Response to Submissions

Project: Additions and Alterations to
Existing Health Services Facility
at President Private Hospital

Date: March 2022

Street Elevation

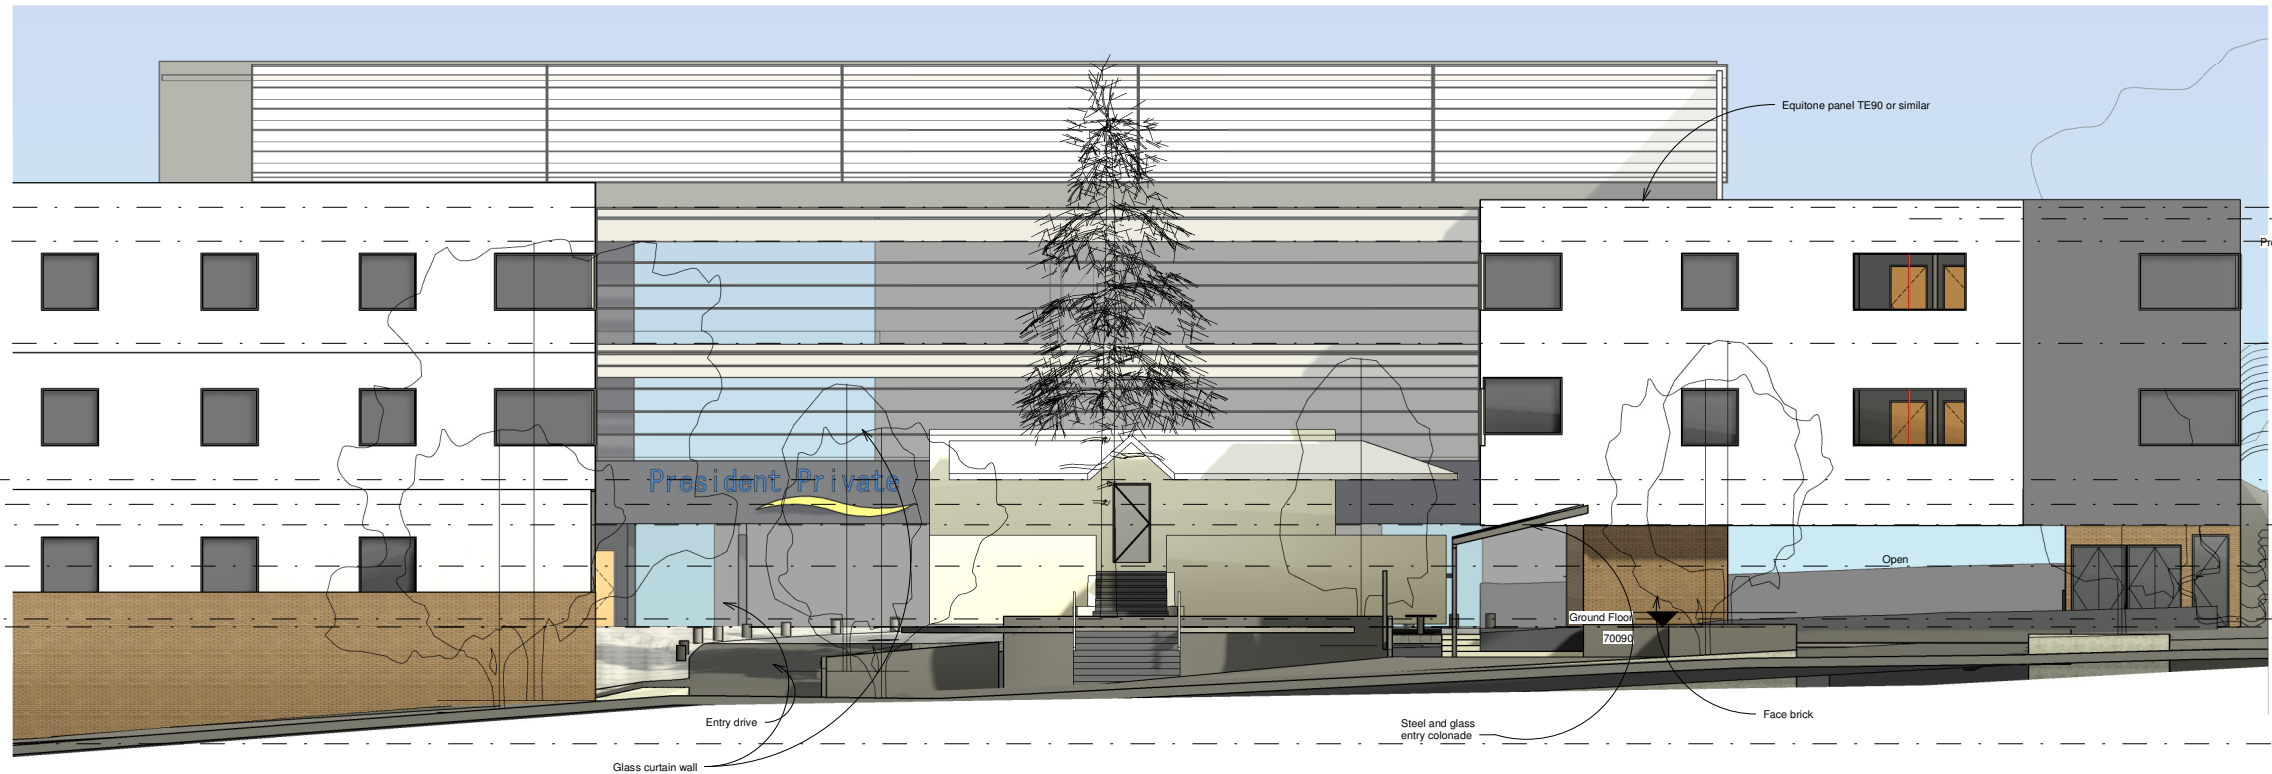
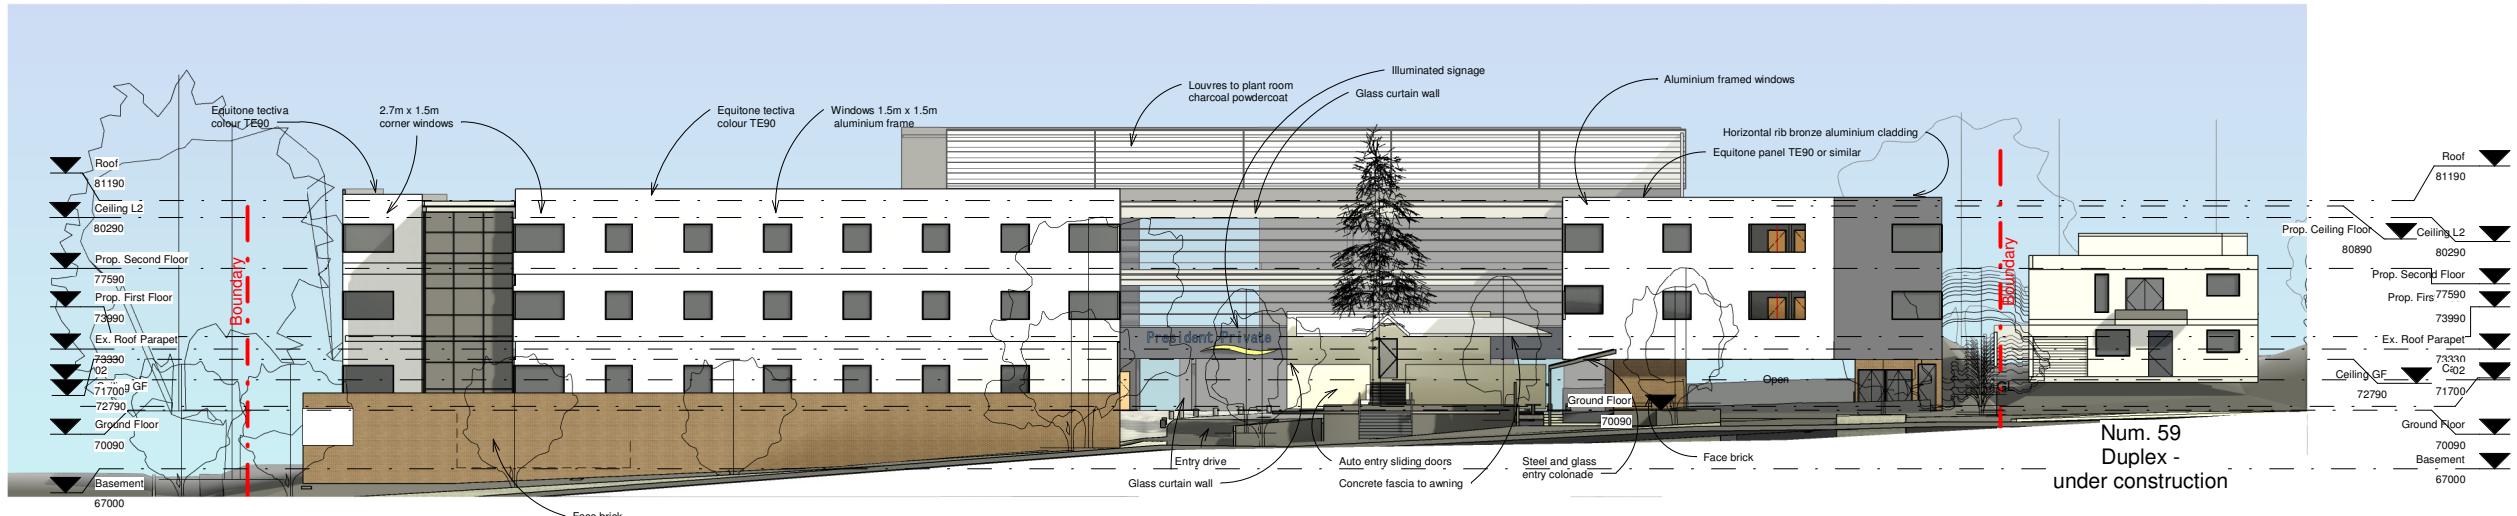
Option D

The remaining structure is of no practical use other than forming an edge to the drop off area.
